**WEST SUSSEX COUNTY COUNCIL
STRATEGIC PLANNING CONSULTATION**

**SUBJECT: LU/197/15 – Approval of matters reserved by conditions imposed under
LU/385/14/PL relating to conditions 3, 8, 10, 11, 12**

Land at Brook Barn Farm, Courtwick Lane, Littlehampton

This report relates to conditions 10, 11 and 12

Pic.3 Parking and welfare layout

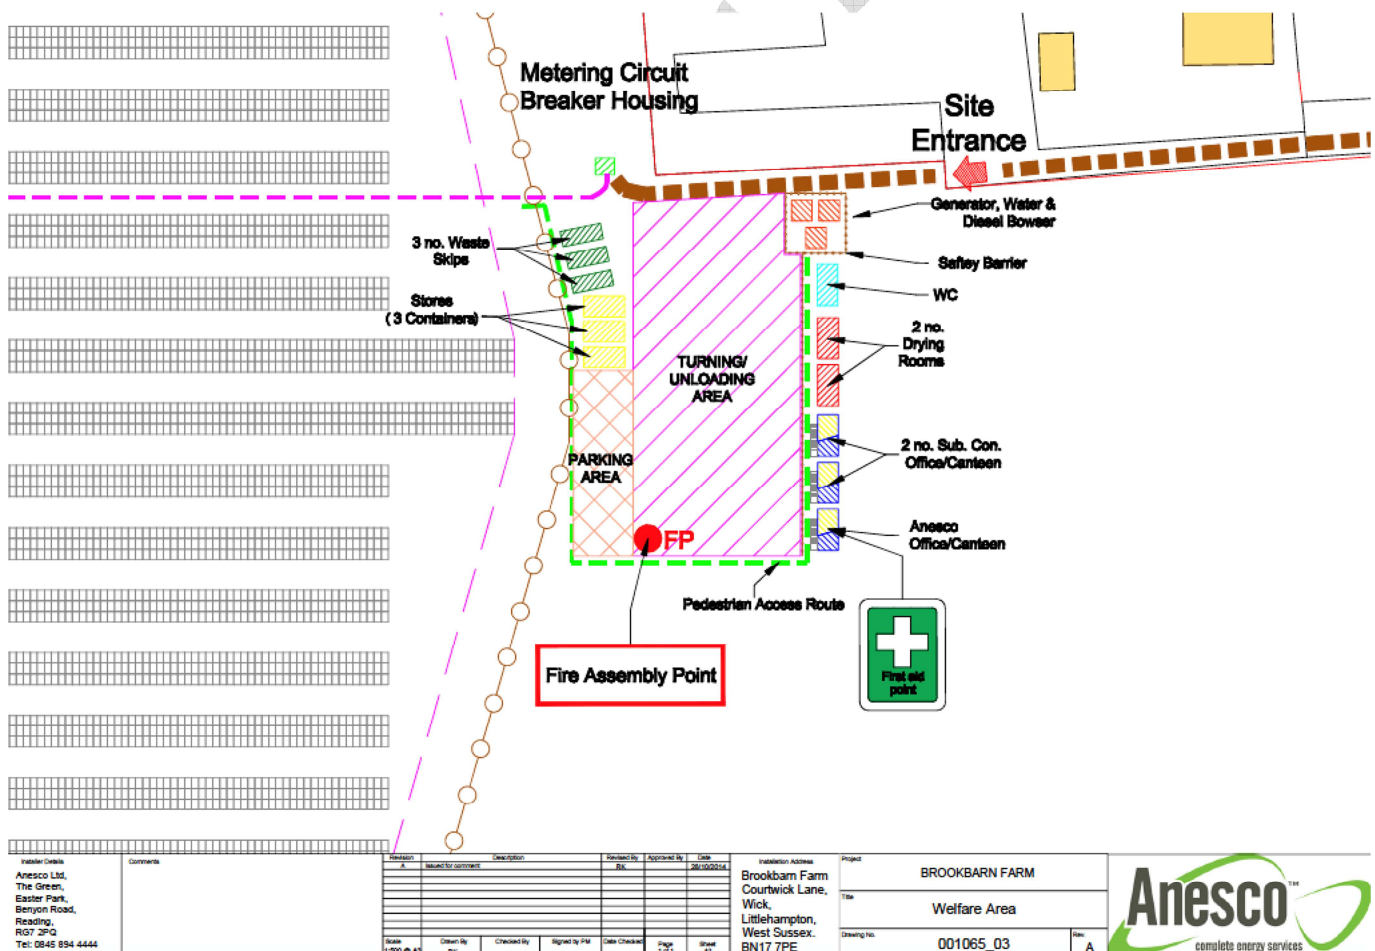
The Traffic Management Plan under section 4 states that 40t HGV's will reverse into the site, however there is no evidence available to suggest there is sufficient room within Old Mead Road to turn. The alternative would be to reverse all the way up Old Mead Road which is not acceptable

It is further stated on page 7 that HGV's will not have to reverse as there is room to turn on site, however there is no evidence to suggest that there is sufficient space for HGV's to turn on site. Can the applicant clarify which vehicles can turn on site and which cannot.
